Administrative Authorization Decision

Application #: 2017-068 **CBL** 080 B008001

Name: 4 Unit Renovation

Address: 548 ST JOHN ST

L1.10

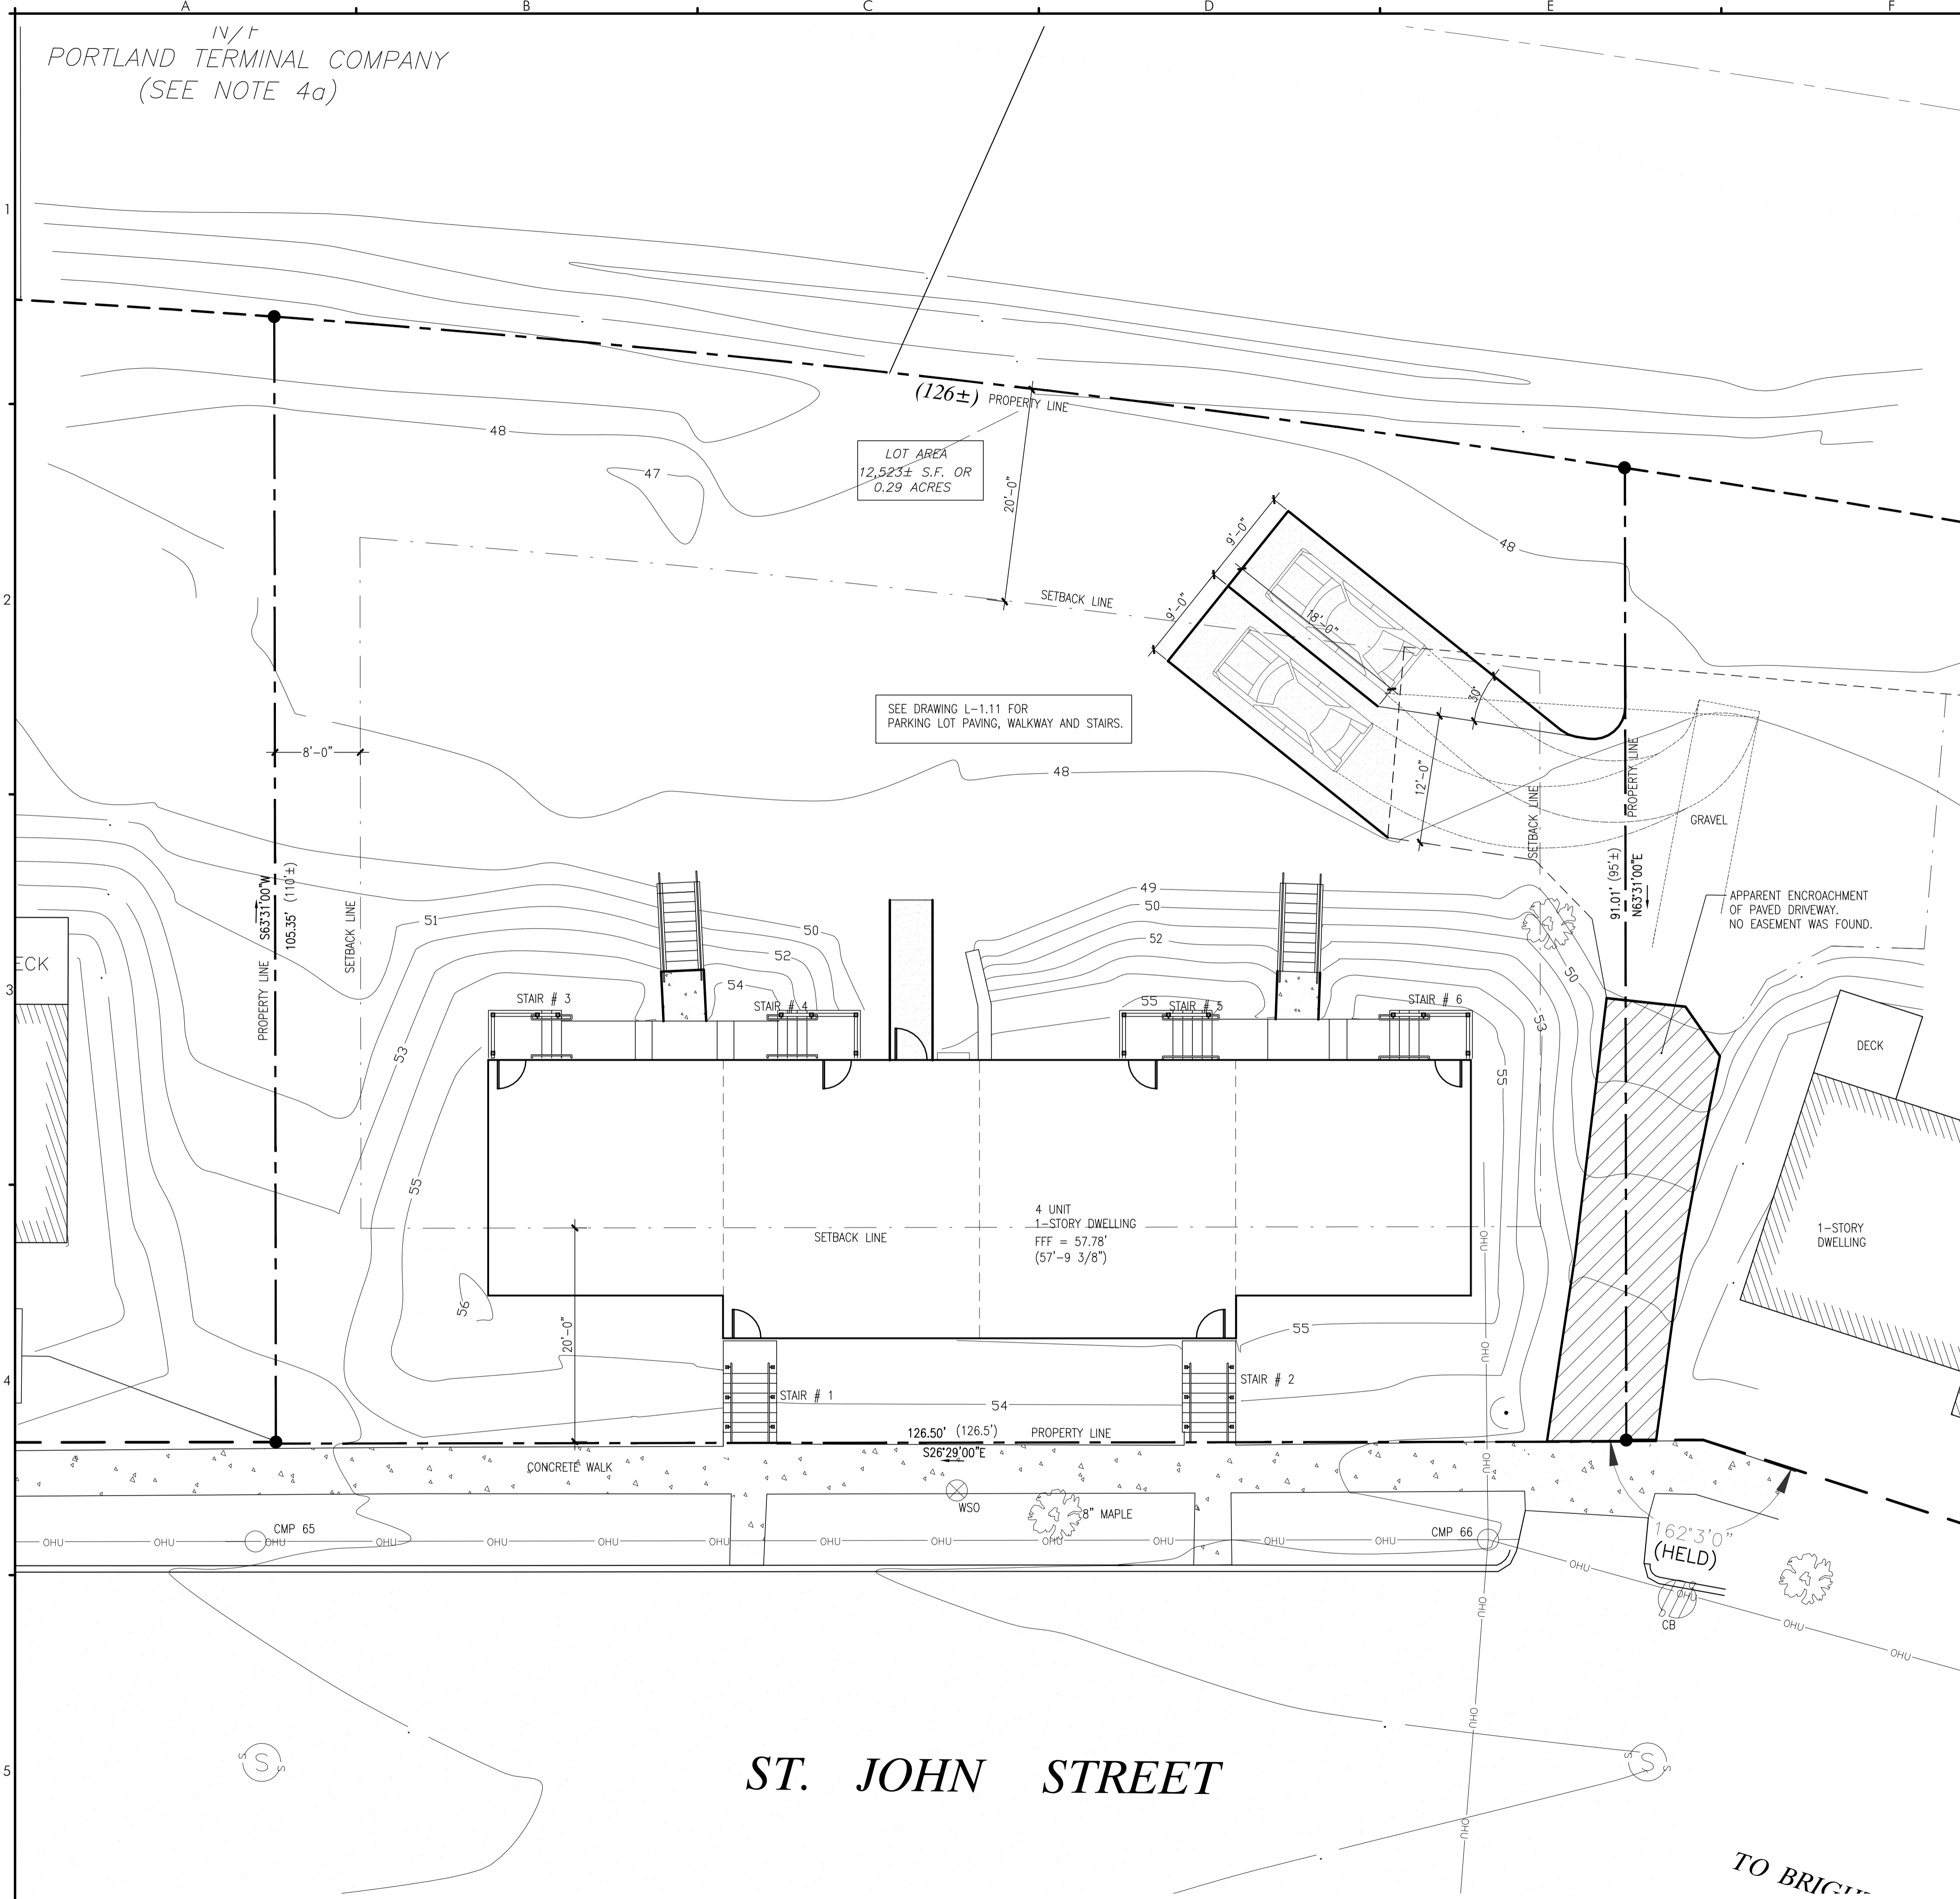
a) Is the proposal within existing structures? <input type="checkbox"/>	Yes	Yes
b) Are there any new buildings, additions, or demolitions?	No	No
c) Is the footprint increase less than 500 sq. ft.?	Yes	Yes
d) Are there any new curb cuts, driveways or parking areas?	No	Yes, a gravel parking area for 2 cars is proposed that is less than 500 sf.
e) Are the curbs and sidewalks in sound condition?	N/A	N/A
f) Do the curbs and sidewalks comply with ADA?	Yes	Yes
g) Is there any additional parking?	No	No
h) Is there an increase in traffic?	No	No
i) Are there any known stormwater problems?	No	No
j) Does sufficient property screening exist?	N/A	N/A
k) Are there adequate utilities?	Yes	Yes
l) Are there any zoning violations?	No	No
m) Is an emergency generator located to minimize noise?	N/A	N/A
n) Are there any noise, vibration, glare, fumes or other impacts?	N/A	N/A

- 1) the applicant shall develop the parking as shown on the site plan. Any proposed pavement or increase in area is subject to further site plan review.
- 2) the applicant shall obtain all required building permits from the Department of Permitting and Inspections.
